# **COUNTY COUNCIL'S RESPONSE TO CONSULTATION ON THE FOLLOWING DEVELOPMENT PROPOSAL**

**Application No:** 18/01246/F

**Proposal:** Change of use of premises from B8 to B1c/B2/B8, including internal and external alterations, demolition of ancillary structures and new access to Southam Road.

## Transport Schedule

Appendix F - Proposed Drainage Strategy

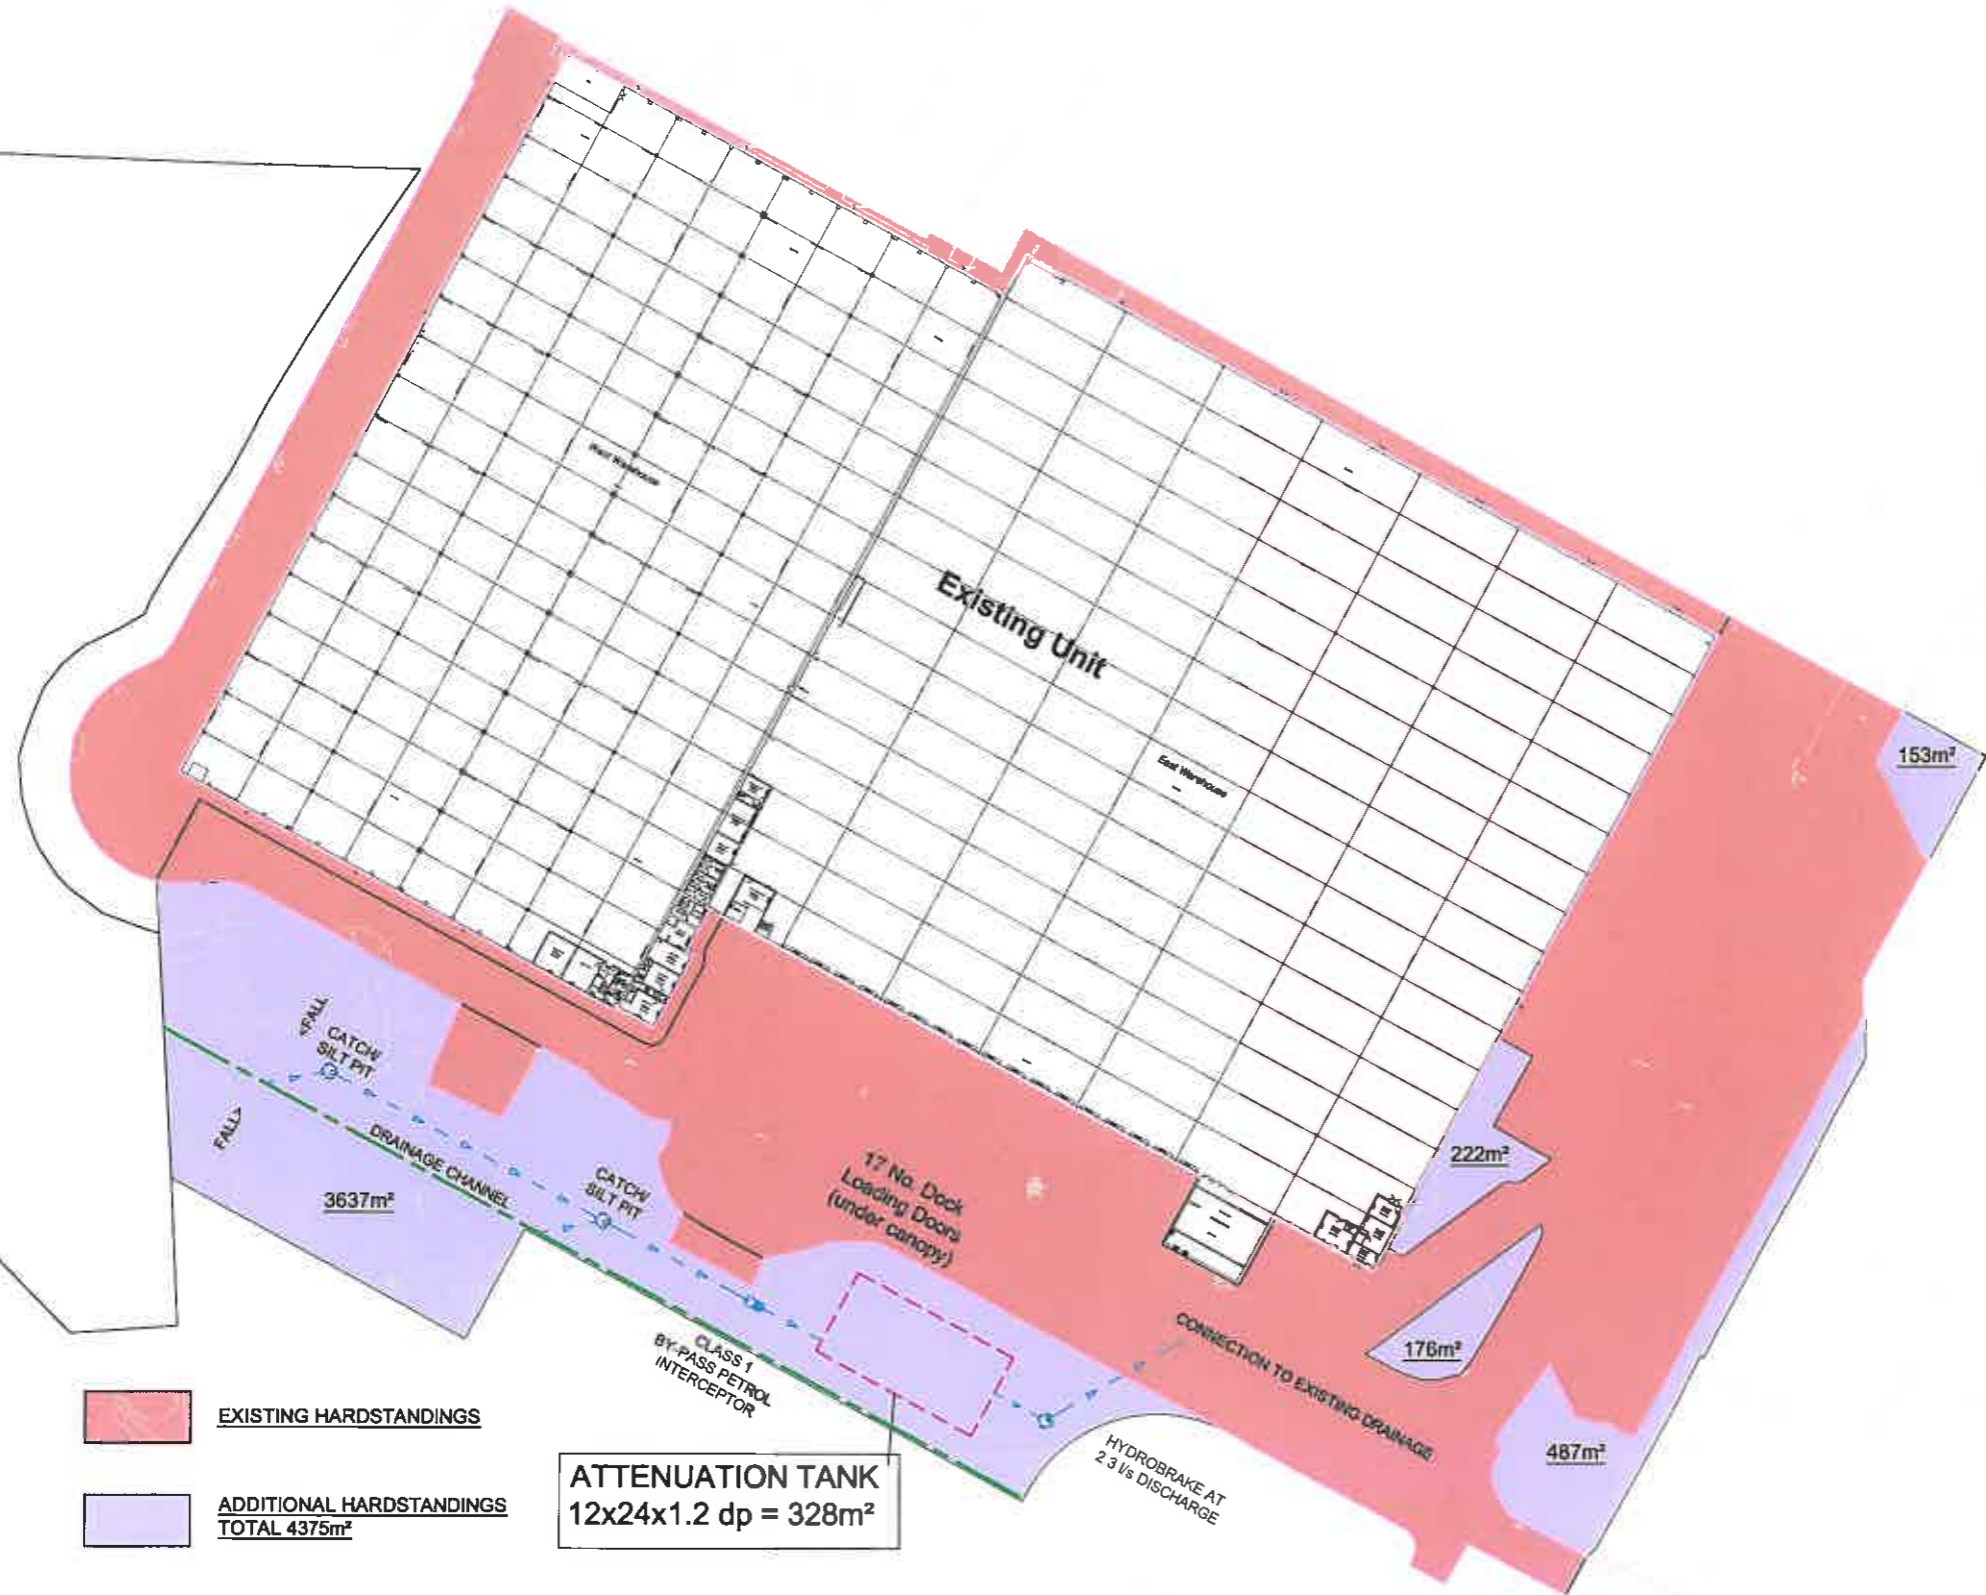
The SuDS proposals include the use of underground attenuation tank to manage surface water so that flood risks are not increased. The surface water will be restricted to outflow at 2.3 l/s in the 100-year (+CC allowance) storm event scenario by the use of a hydrobrake. Full detailed design details of the proposed SuDS system were not provided within the FRA and it is proposed to undertake a survey of the existing system on site so that levels and pipe sizes can be confirmed.

As well as the consideration of the modelled events, there should be a qualitative examination of what would happen if any part of the drainage/SuDS system fails, to demonstrate that flood water will have flow routes through the site without endangering property and where possible maintaining emergency access/egress routes. This should be supported by a flood exceedance route plan.

Access Road Realigned to South to allow two way HGV flow

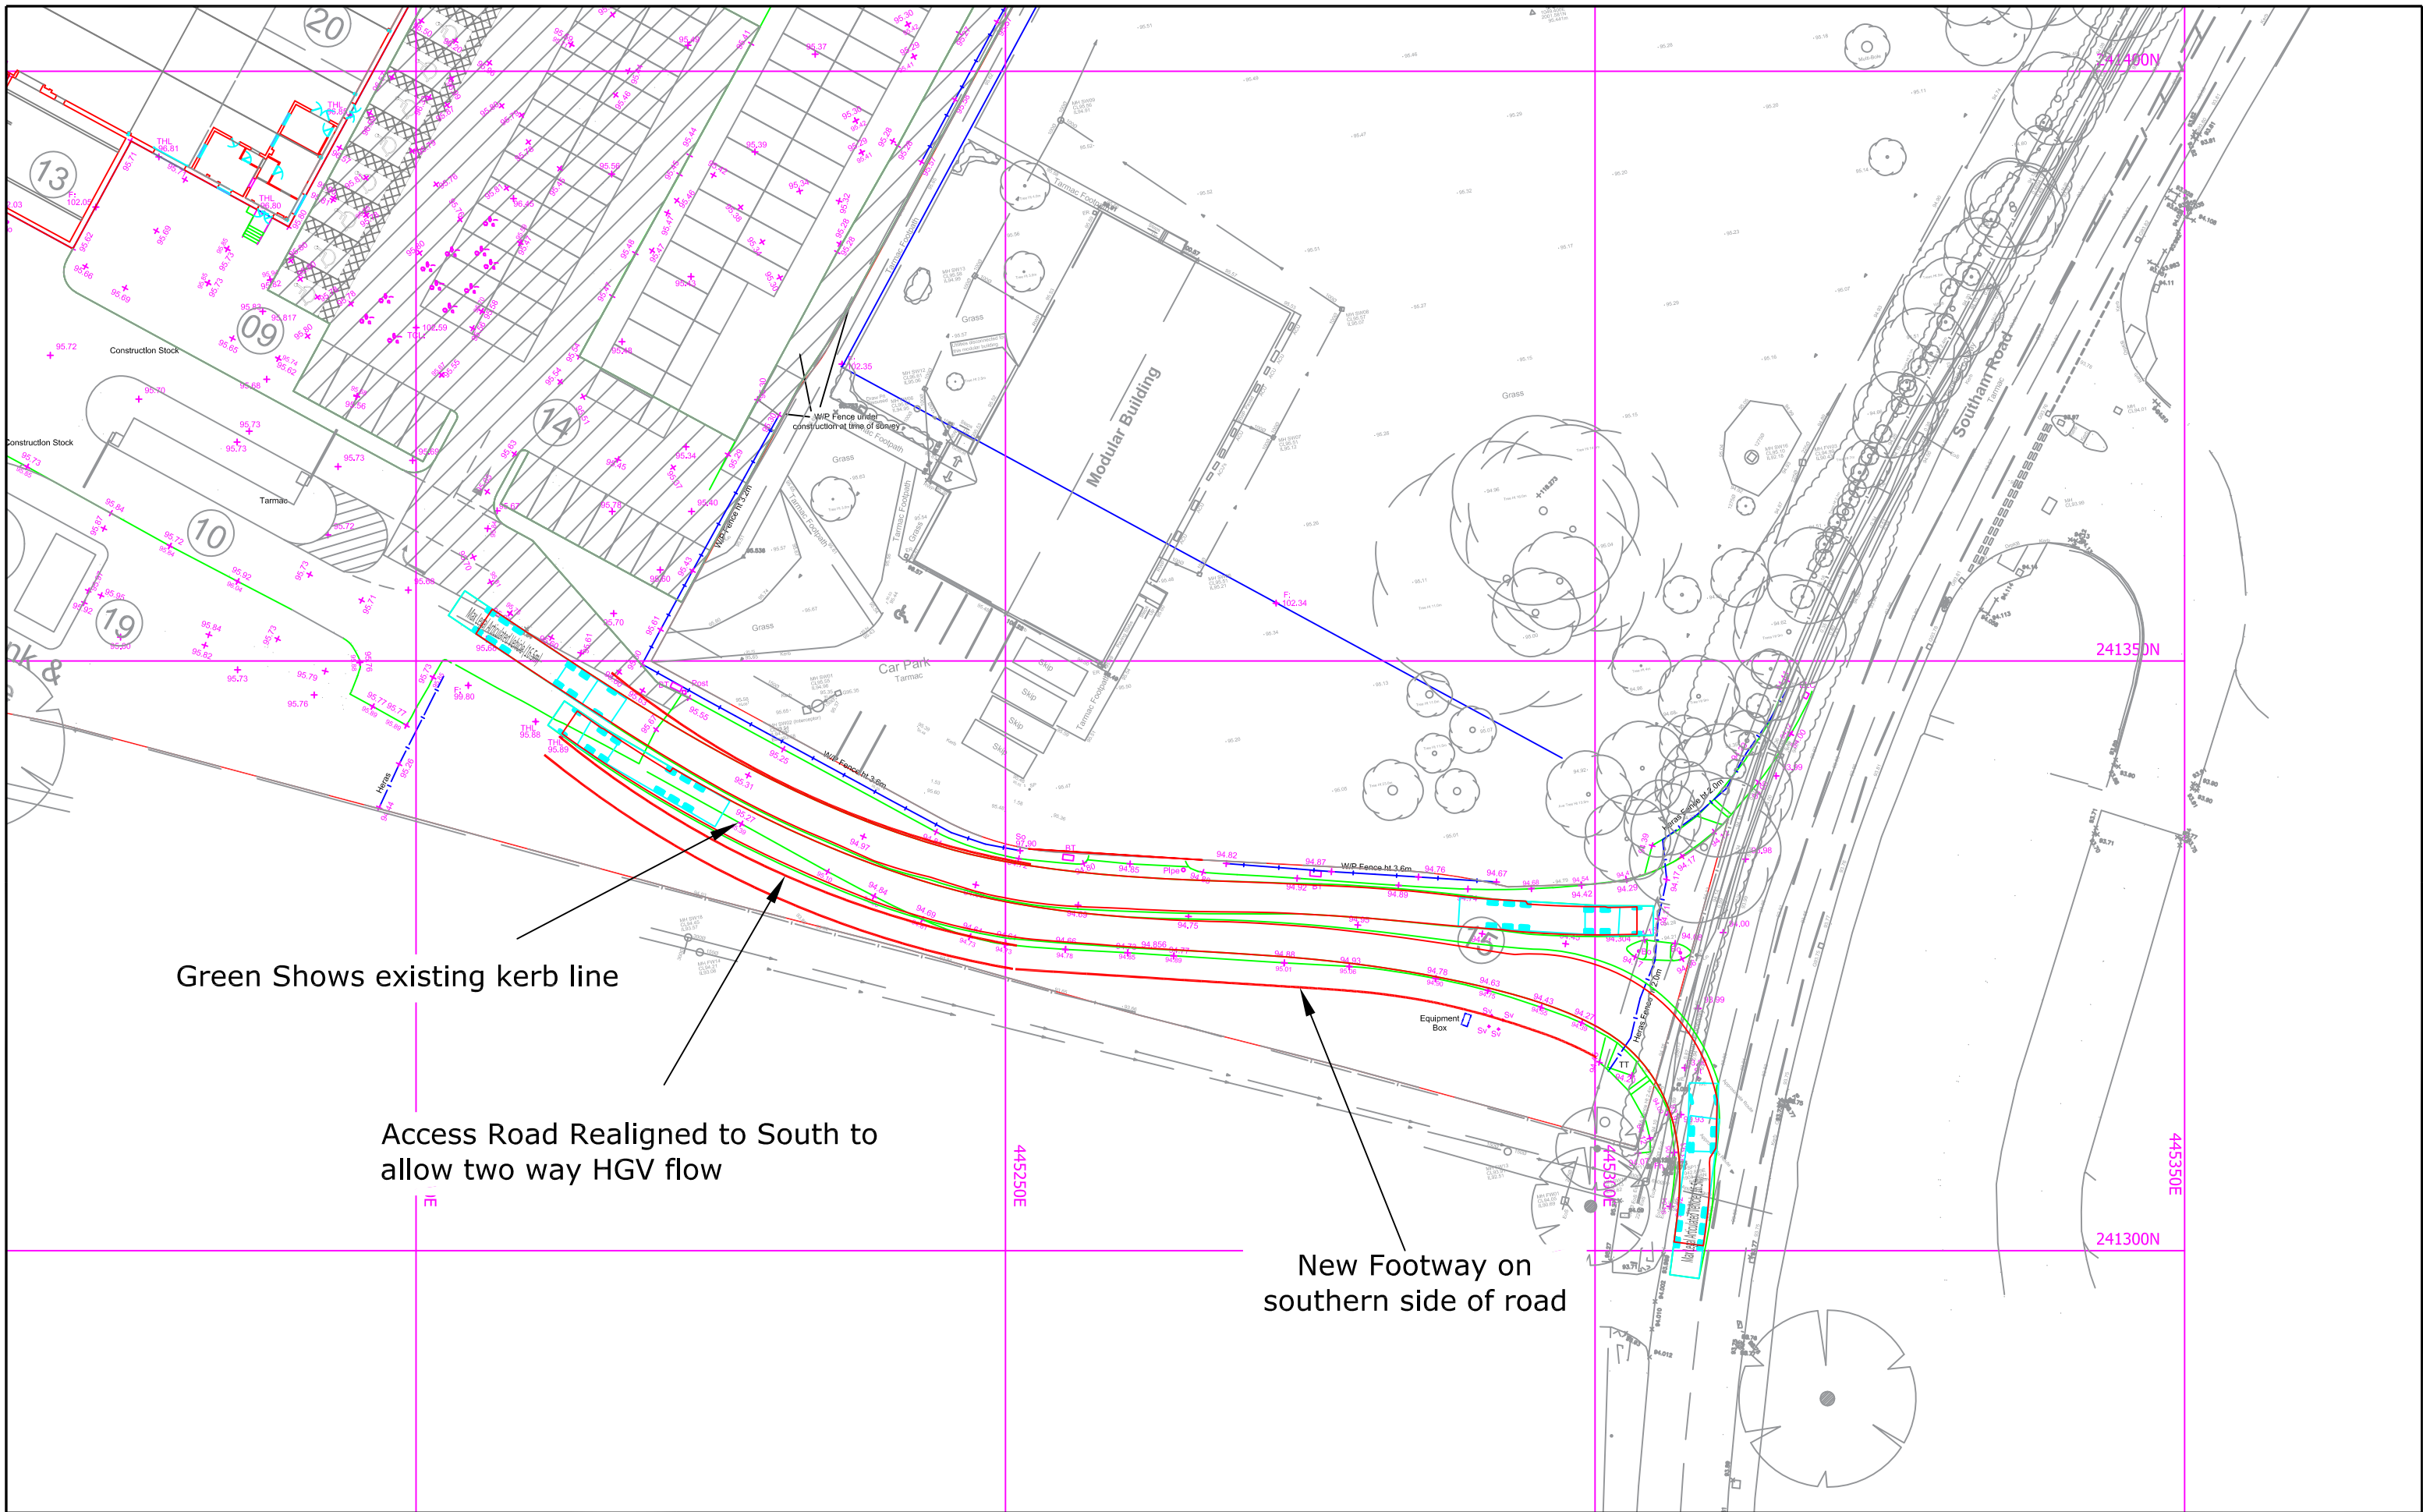
The site currently benefits from vehicular access from Ruscote Avenue. Although this application claims access off Southam Road as existing, the access does not serve the site yet and this only became available following the recent construction of Waitrose. The proposed access was thus brought in existence in connection with a servicing access for the supermarket. Oxfordshire County Council (OCC) as Local Highway Authority (LHA) hereby find it necessary to carry out an assessment of the access junction relative to the development flows on Southam Road.

Assessment of the access will need to consider for both car and HGV turning into the site which will need to be demonstrated by use of PICADY software for junction capacity. Other issues that are concerning regarding the proposed access are;

- Southam Road is about 6.5m wide including an on-carriage cycle lane which further reduces the effective carriageway width. I do not see any scope of localised widening (citing land constraints), which is not convincing that right turning vehicles (in the absence of a right turning pocket) shall not interfere with onward traffic movement.
- Access arrangements need to be accompanied by swept path analyses of the vehicles likely to visit the site. This would include 16.5metre articulated trucks and 12metre rigid lorries.
